FINAL DRAINAGE REPORT ADDENDUM

SUNSET VILLAGE FILING NO. 4

PCD File No. CDR-218

December 3, 2021

DETENTION POND

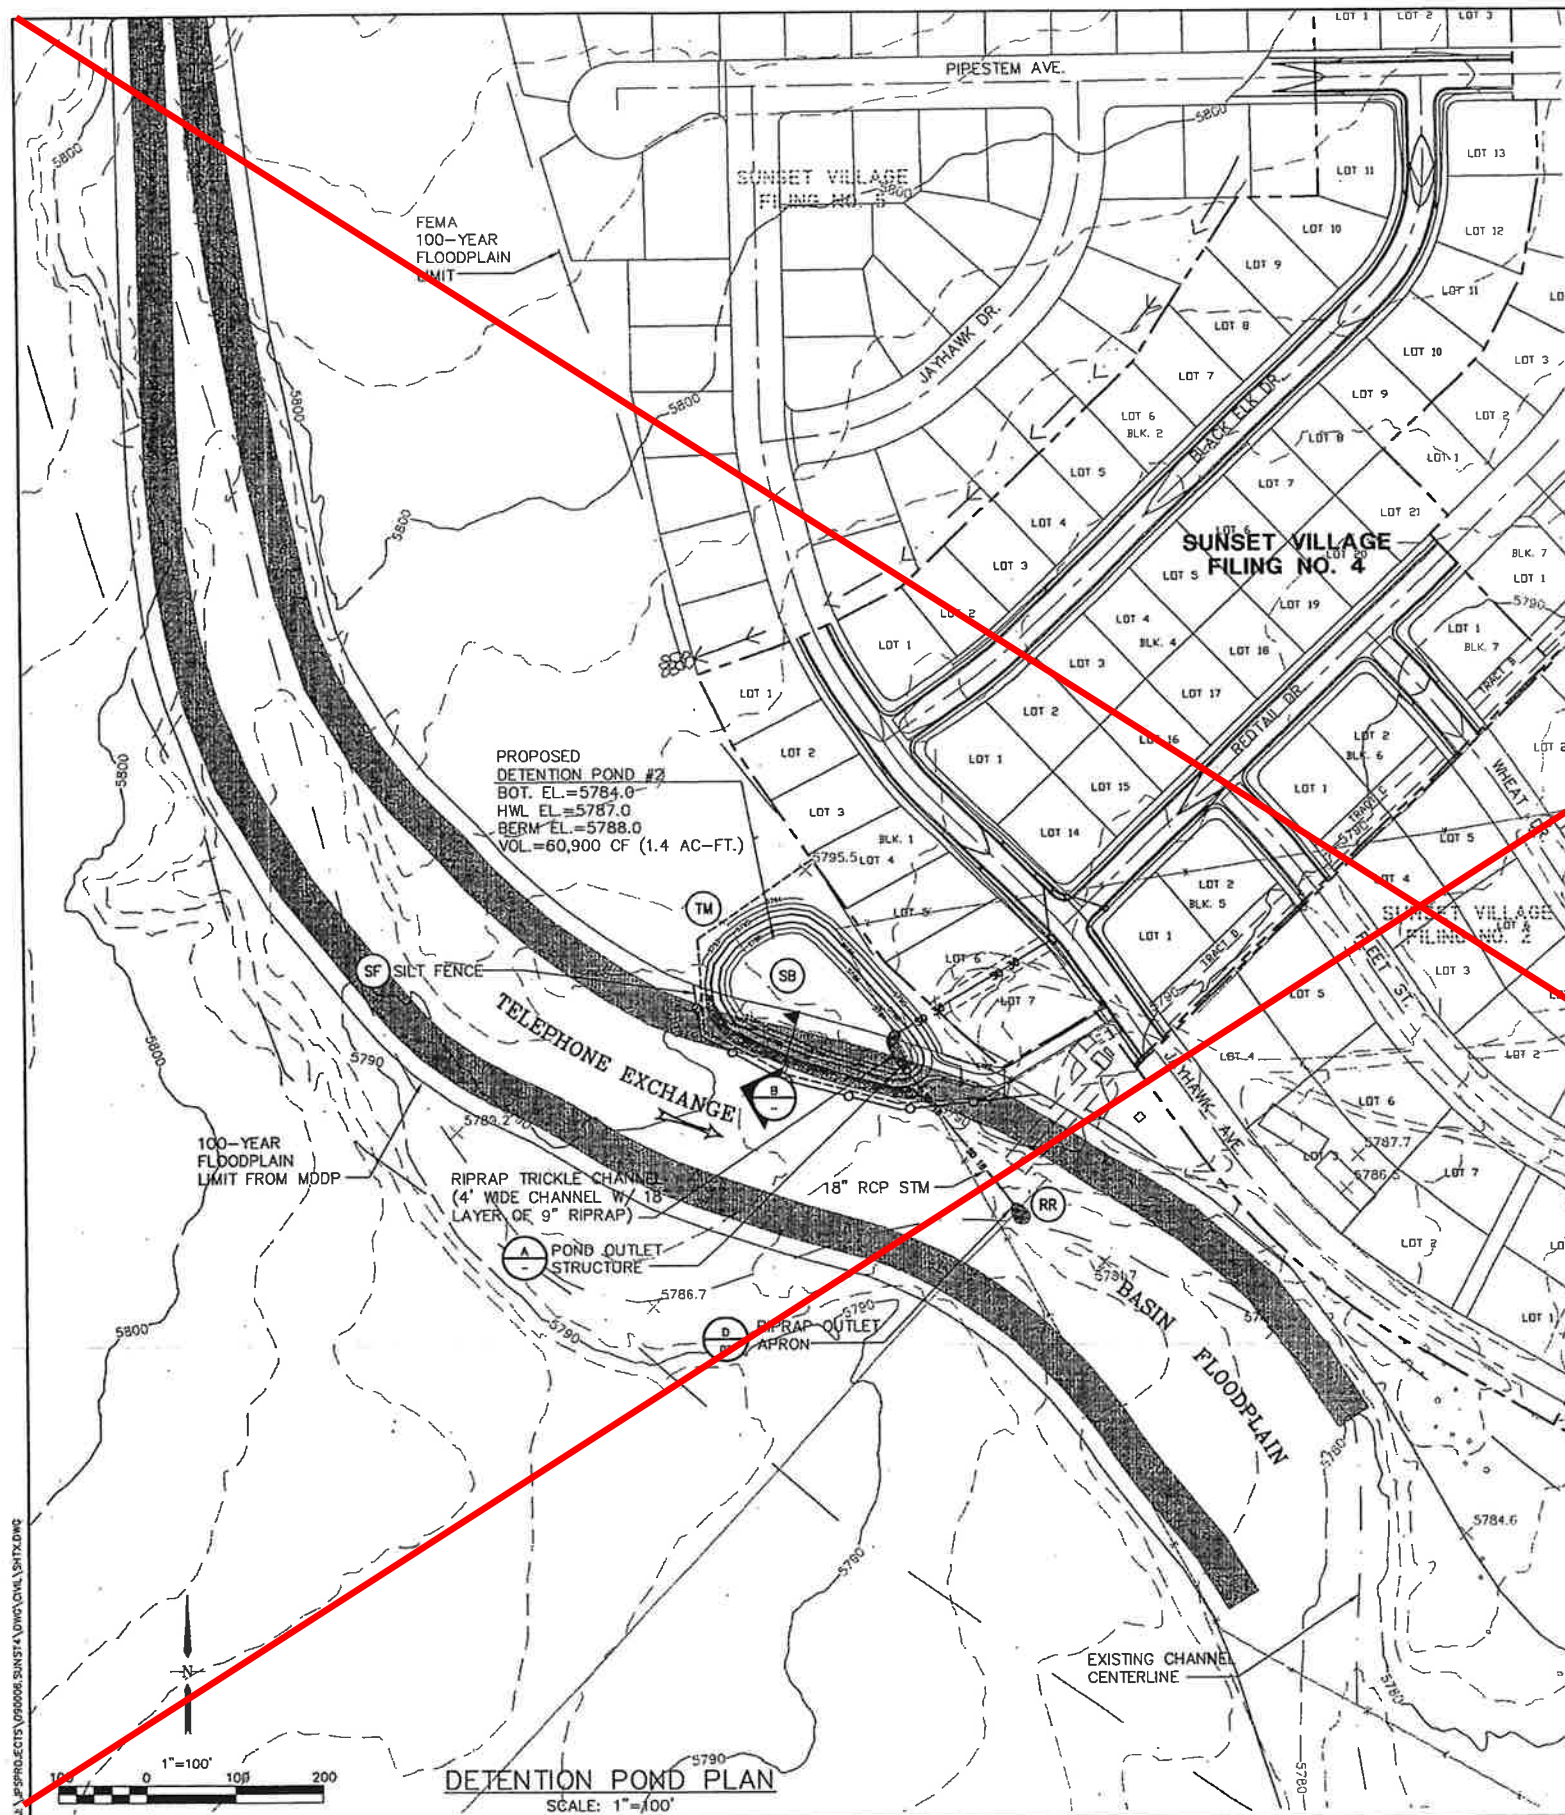
Add construction cost estimate for the pond retrofit.
